PRELODGE MENT PANEL ADVICE EIS CONSULTATION AND ADVICE

PROPERTY:	2-4 Giffnock Avenue, Macquarie Park	
MEETING DATE:	5 June 2025	TIME: 2pm to 3pm
PRELODGE MENT No:	PRL2025/0014	
DEVELOPMENT:	Mixed-use development comprising two tower elements above podiums, with retail premises, a childcare centre and residential uses within the building envelopes and recreation and infrastructure uses on the remainder of the site.	
ATTENDANCE:		
Council:		
Nicholas Najar	Acting Senior Co-Ordinator Development Advisory Service	
Michael Cuthbert	Infrastructure Strategy & Planning Coordinator	
Mark Taylor	Senior Coordinator Park Planning	
Daniel Pearce	Senior Coordinator Engineering & Landscaping Services	
Joey Huang	Acting Senior Coordinator Transport Development Services	
Robert Platt	Development Contributions Coordinator	
Leila Faghihi	Senior Engineer Stormwater & Floodplain Management	
Justin Byrne	Senior Civil Engineer Activation & Compliance	
Jeremy Giacomini	City Architect

Drawing Title
STORMWATER CONCEPT PLAN
GROUND FLOOR

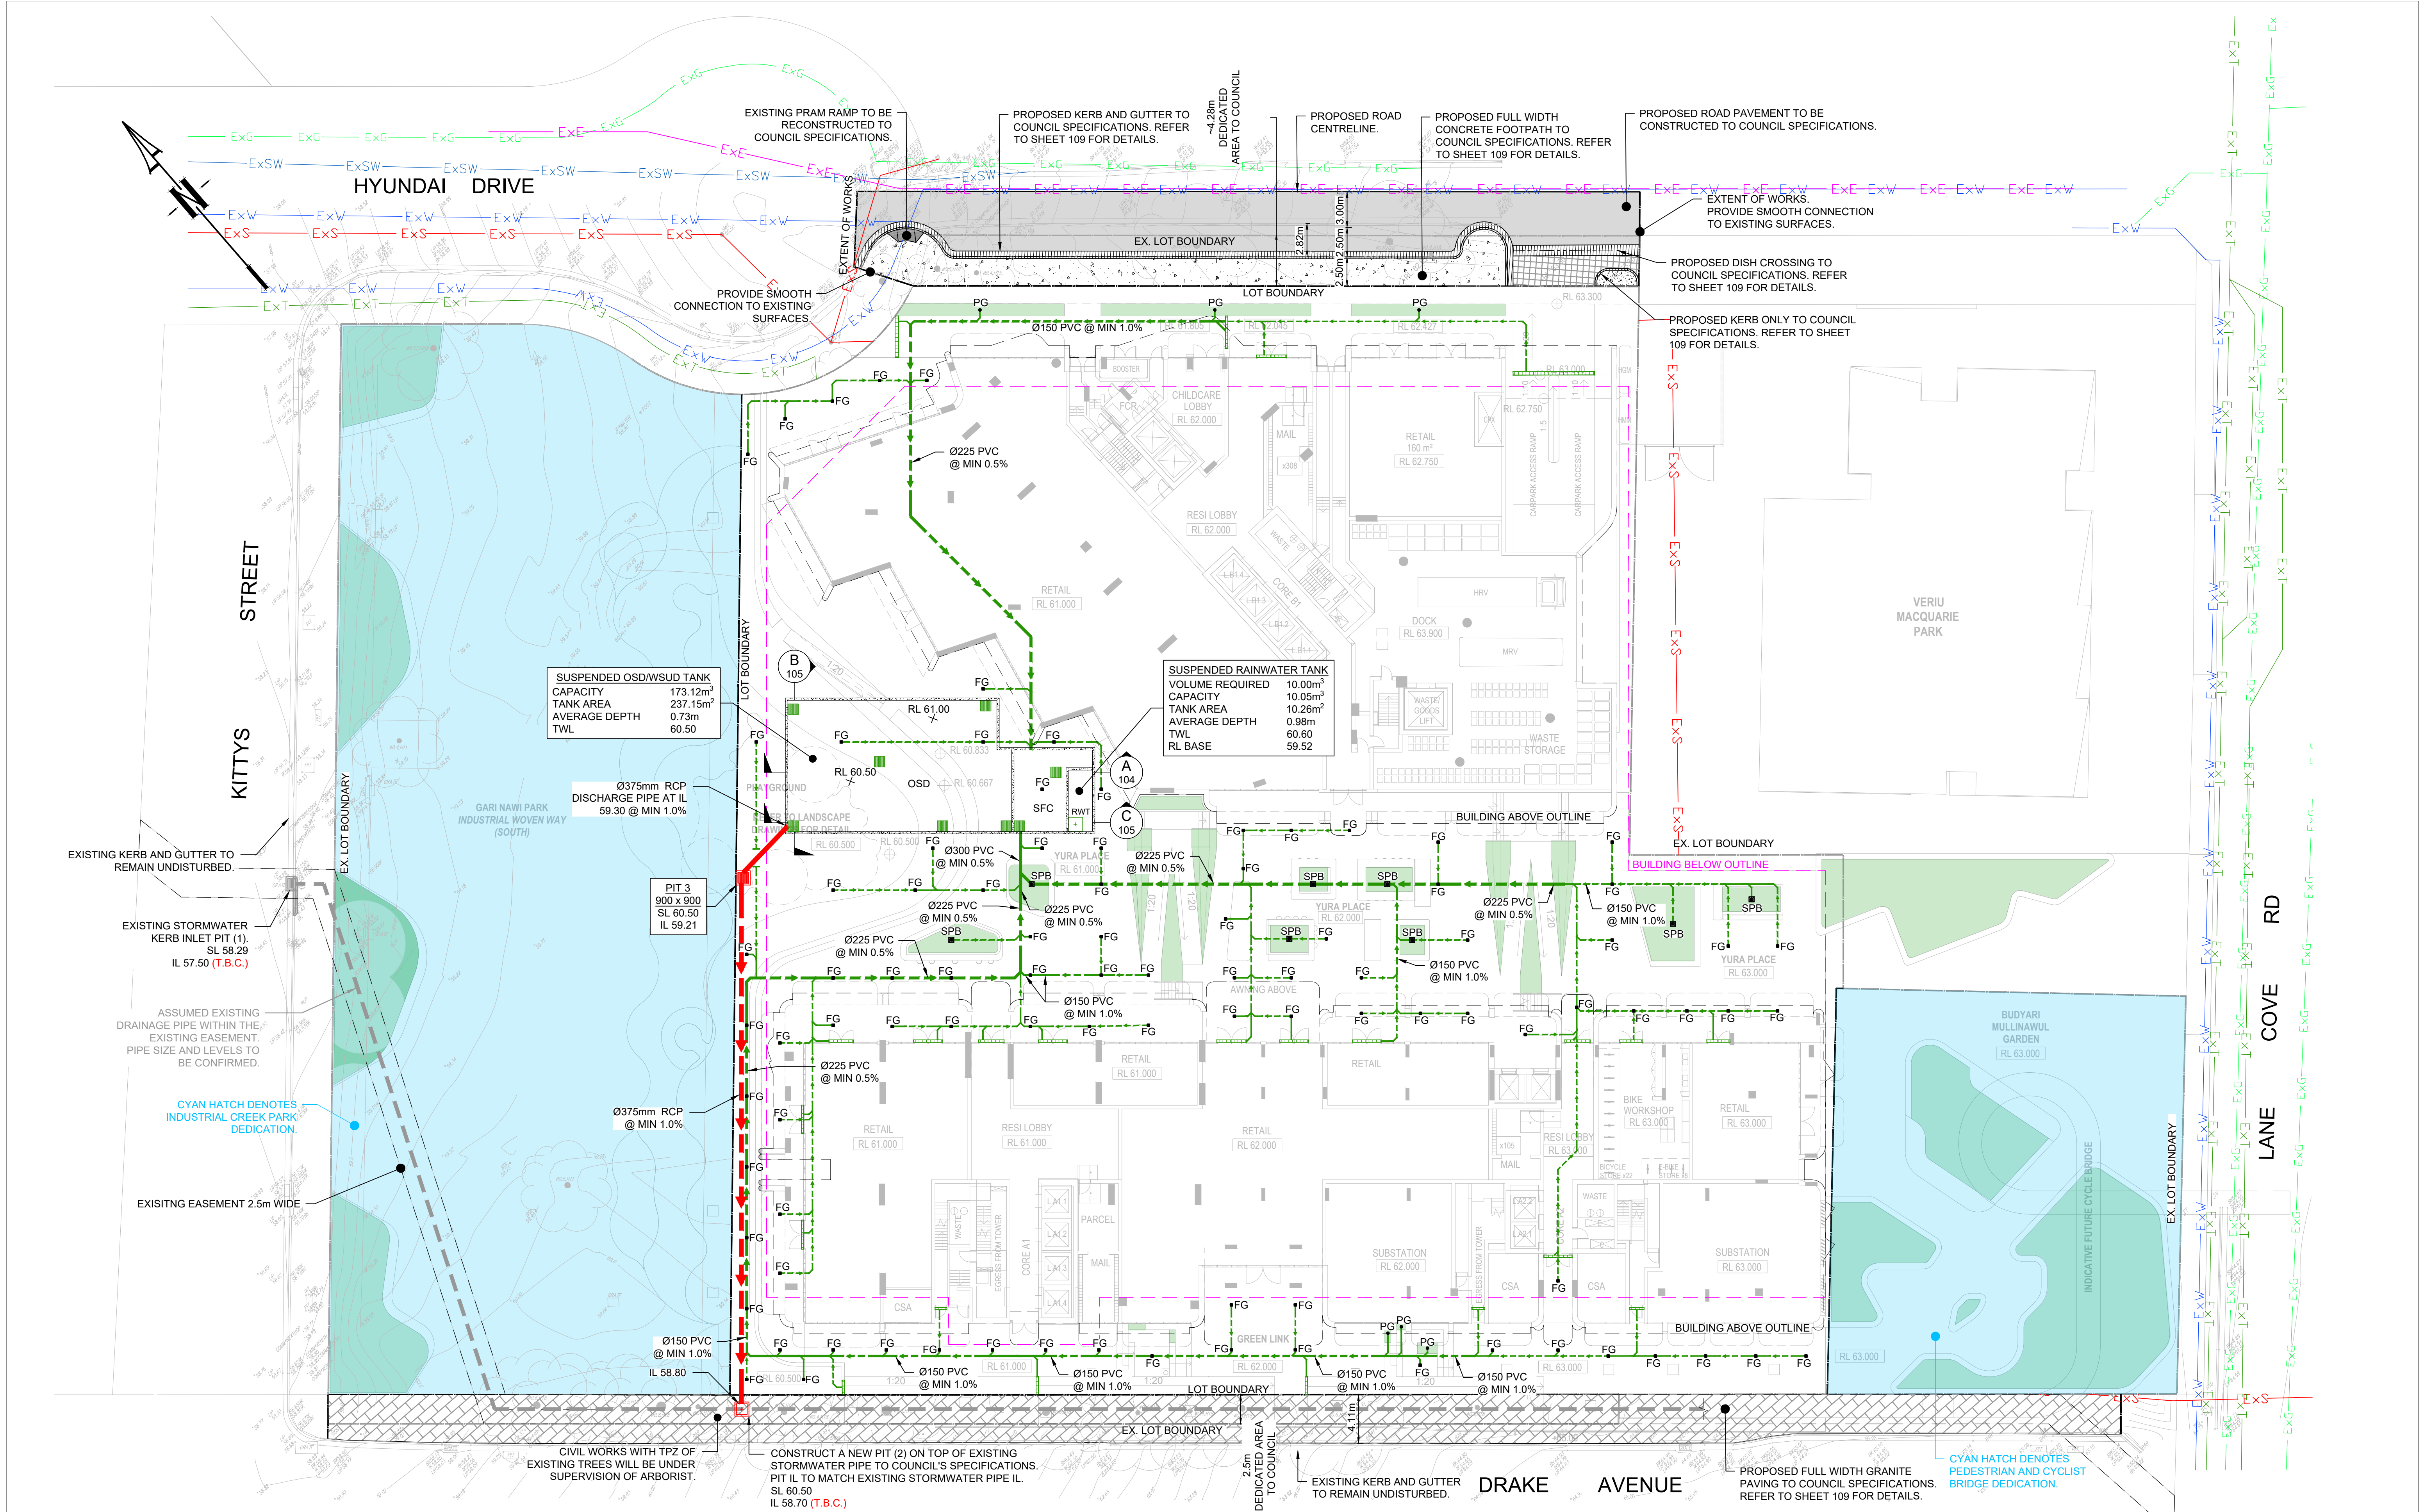
RLEP 2014 Clause 6.4 applies to the development. Site is noted to fall to the public road frontage (Giffnock Avenue) and therefore does not present any significant, fundamental concerns concerning drainage of the site.

As per Council's DCP requirements, onsite detention (OSD) must be implemented in the stormwater system. The system must be designed in accordance with the DCP Part 8.2 (*Stormwater and Floodplain Management*) utilising the detailed method (refer to the associated Technical Manual to this DCP Part).

- The system must be located at the lowest point of the site, close to the discharge point, so as to ensure that the entire development could readily be routed through it.
- The failure mode for the OSD system must be accounted for. This requires consideration for stormwater to surcharge from the detention storage, ensuring there is provision for the safe conveyance of stormwater away from habitable areas, should the discharge line / discharge control be blocked.
- Above ground basins which are landscaped must have the volume increased by 20% to account for landscaping in this area.

The scale of development will warrant WSUD measures be implemented as per Section 3 of the DCP Part 8.2 (*Stormwater and Floodplain Management*). The use of or integration of WSUD elements into the landscaping features of the development is strongly encouraged.
